**RFI**

RFI #: 80  
Date: 3/20/2012  
Job: EB-02 Keller Springs Lofts  
Phone: 877-777-5115

Subject: Elevation conflict with floors

DATE	08-05-2011	SHEET NUMBER	3.1
PROJECT	11129

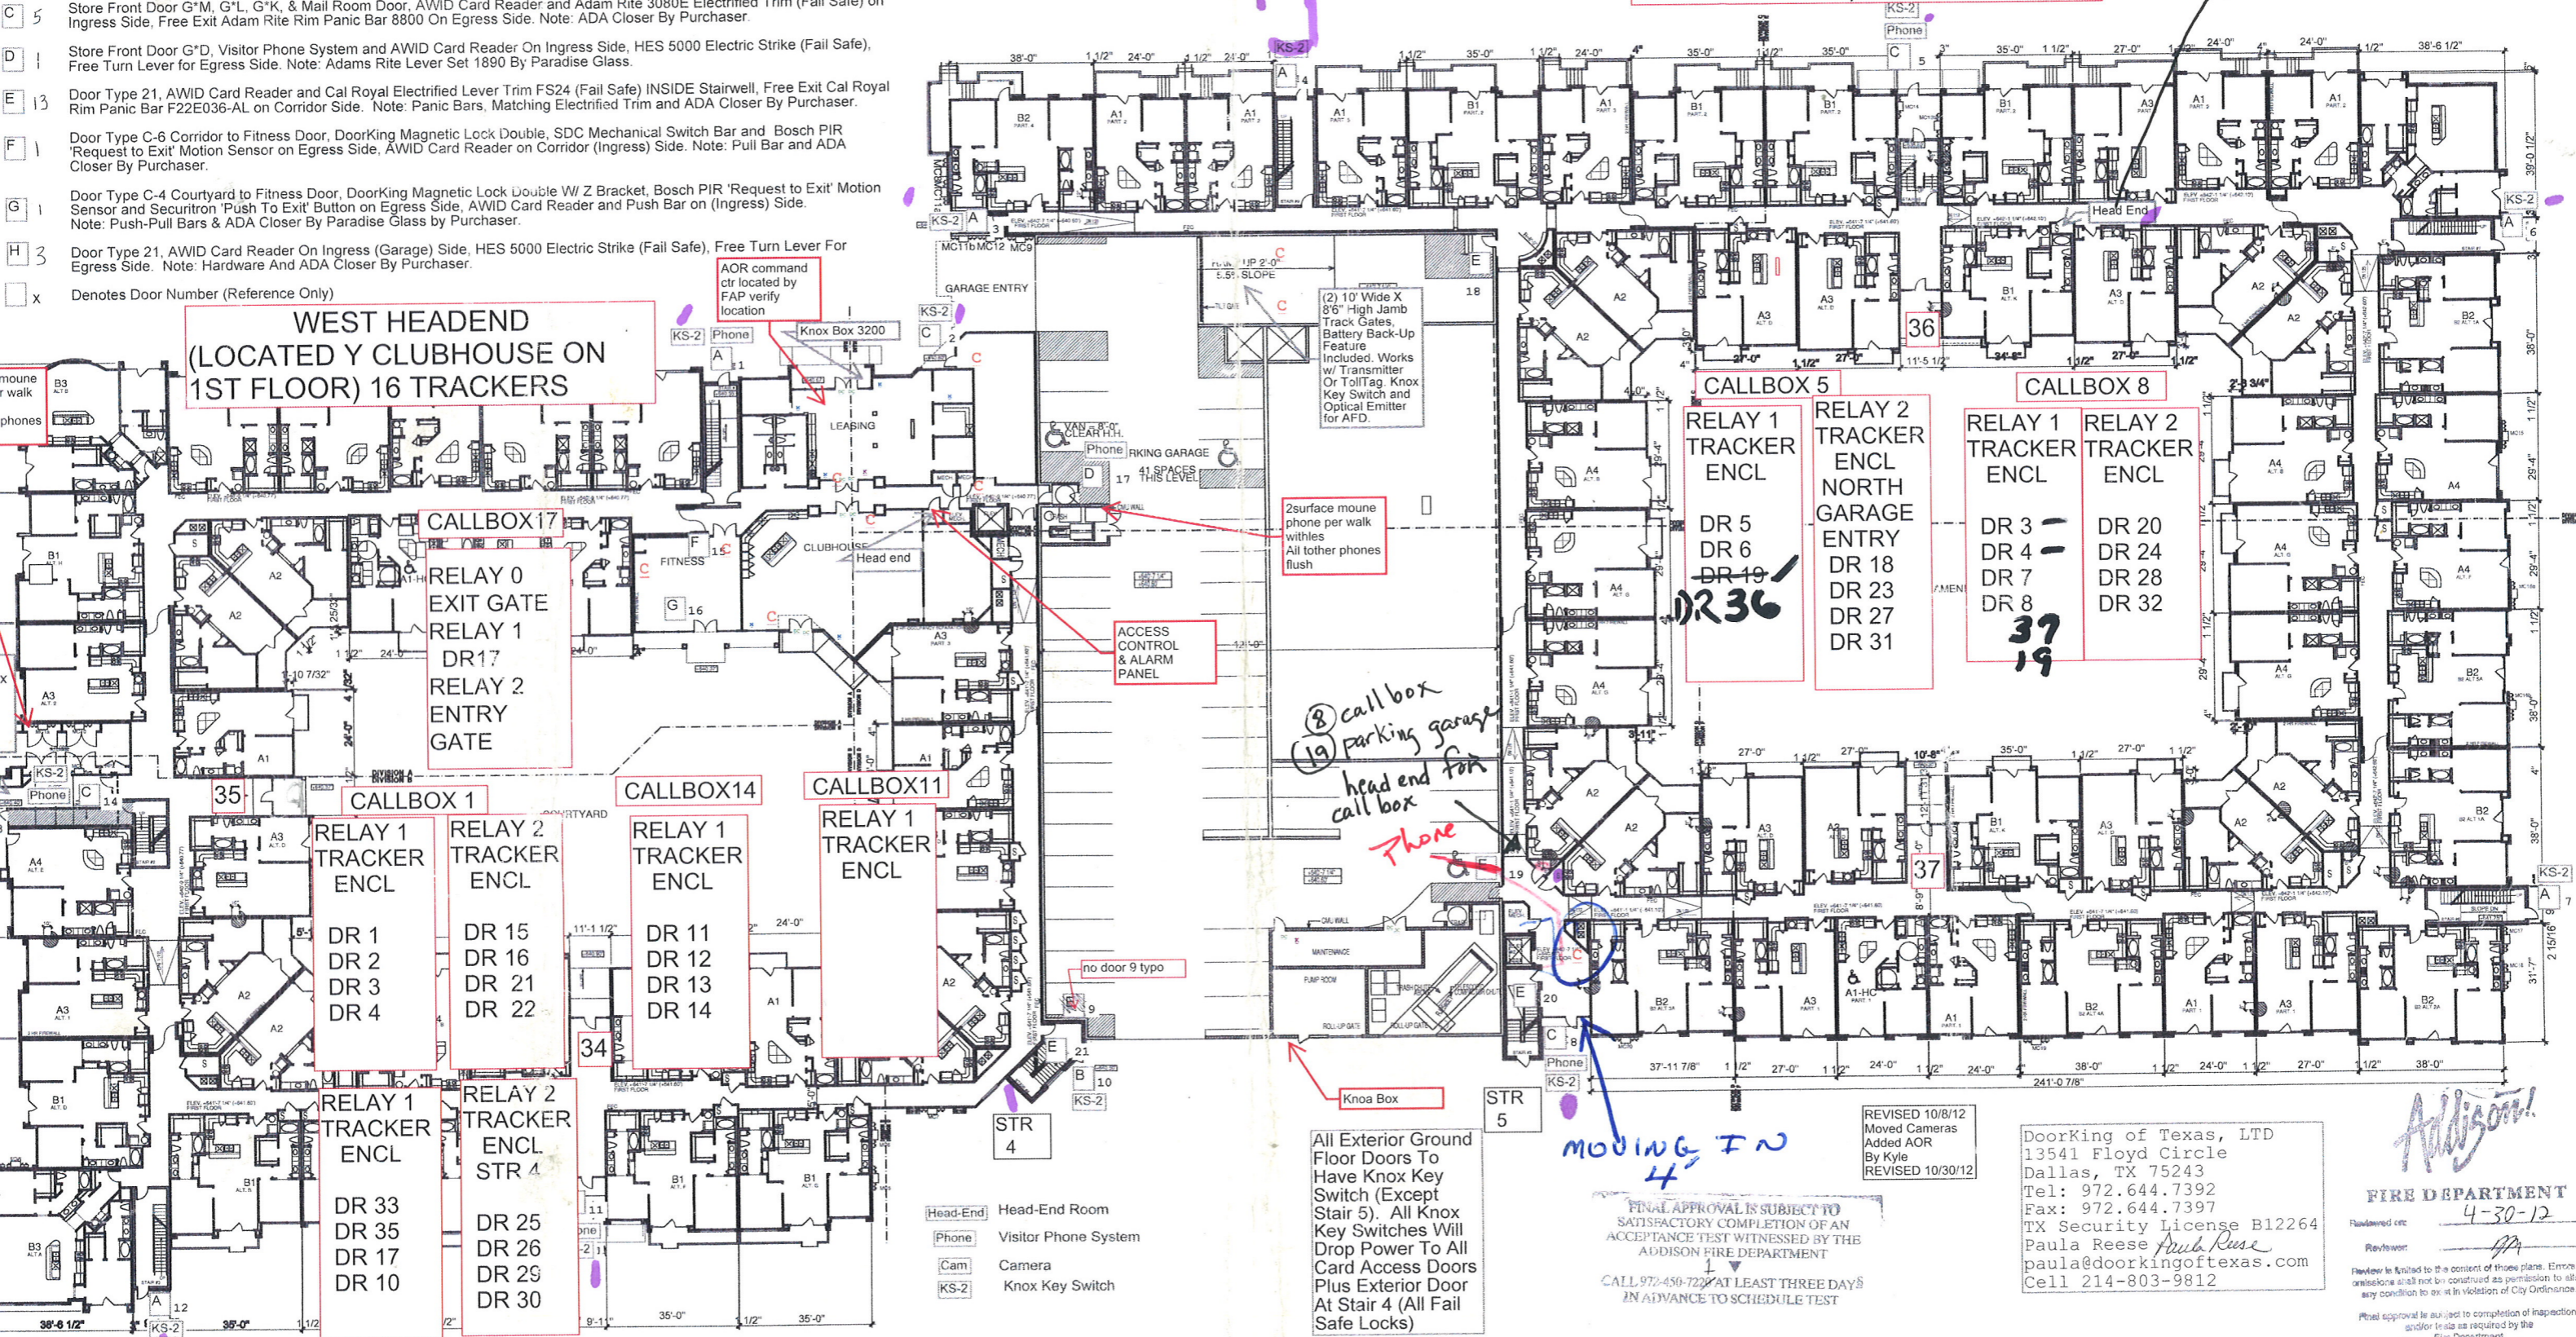
**Request:** Date Required: 3/27/2012  
Erik the following concern has been brought up by our framing subcontractor.  
Response to the RFI #48 answer  
Thank you for addressing RFI #48. Your answer to #48 has us installing an additional 1x to the bottom plate to achieve specified elevations at 2nd 3rd and 4th floors around the parking garage. We do agree with adding the 1x to 2nd and 3rd floor bottom plates, but we think it should be to the entire 2nd and 3rd floors. The problem that we resolved around the garage is still present at the other stairwells. Here is a list of potential problems with installing the 1x to only parts of the floor

- 1 we will have step downs in the corridor ceilings  
- 2 we will still have elevation problems at stairwell #s 1-2-3-6-7-8  
- 3 floor plate differences at exterior elevations

- 4 the ramping of the floors (that you have addressed)  
- 5 we will have to add a 1x to top of 4th to all areas not raised or field out all of the studs in your shaded area to achieve proper roof truss bearing.  
In summary we think that we should install the 1x to all of 2nd and 3rd floor bottom plates. Erik this was previously discussed with the Project Manager David Gallagher, the Project Super Brian Peterson and with you and agreed upon by all parties.

**Response:** BGO agrees and has no exception to this change.
